# CITY OF ALBUQUERQUE

**Re: Jefferson Hotel**  
**4949 Jefferson St. NE**  
**Request for Certificate of Occupancy**  
**Transportation Development Final Inspection**  
Engineer's/Architect's Stamp dated 9-10-18 (F17D044C)  
Certification dated 7-28-20

Based upon the information provided in your submittal received 7-28-20, Transportation Development cannot approve the release of Certificate of Occupancy for the above referenced project.

JEFFERSON
HOTEL
TRAFFIC CONTROL
LAYOUT

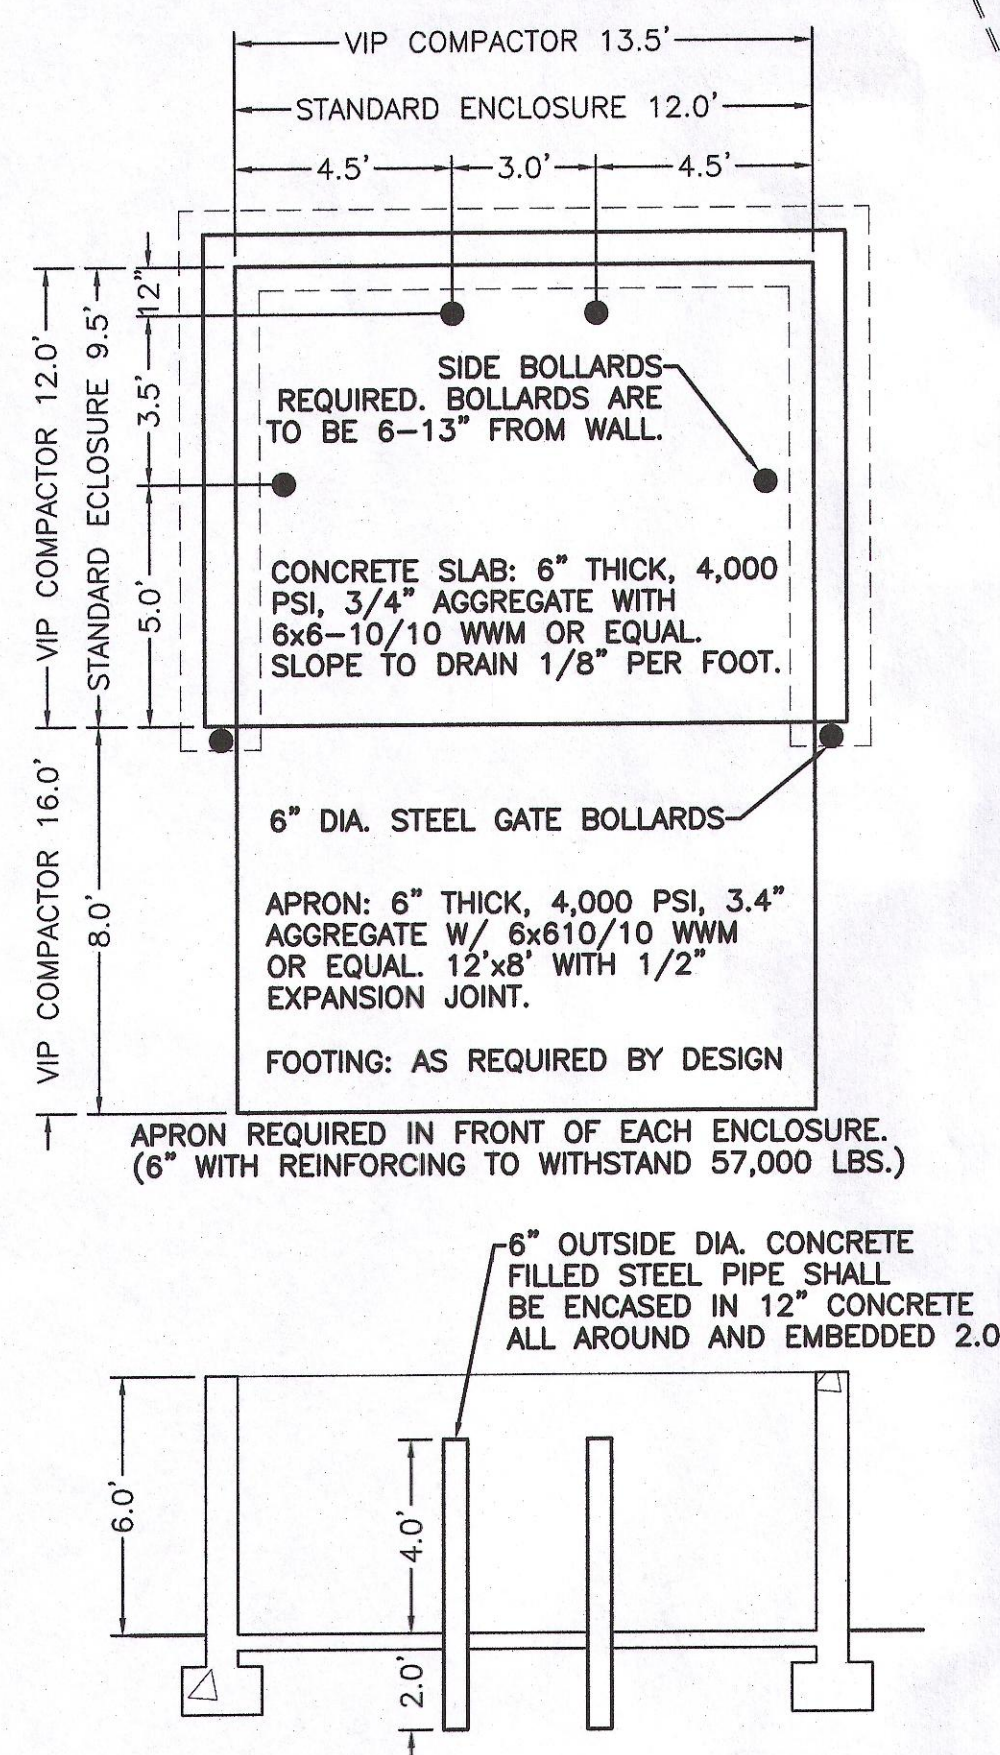
- Please complete concrete for ADA access from sidewalk to public entrance of Building. (See Plan for locations)
- Please add ADA ramp (See Plan for location)
- Please complete asphalt parking.
- Please add truncated domes to wheelchair ramps located in the public right of way.

1. The approved and stamped TCL with changes drawn in red.
2. Transportation Certification letter on either the plan or applicants letterhead.
3. A Drainage Transportation Information Sheet (DTIS)
4. Send an electronic copy of your submittal to [PLNDRS@cabq.gov](mailto:PLNDRS@cabq.gov).
5. The \$75 re-submittal fee for log in and evaluation by Transportation.
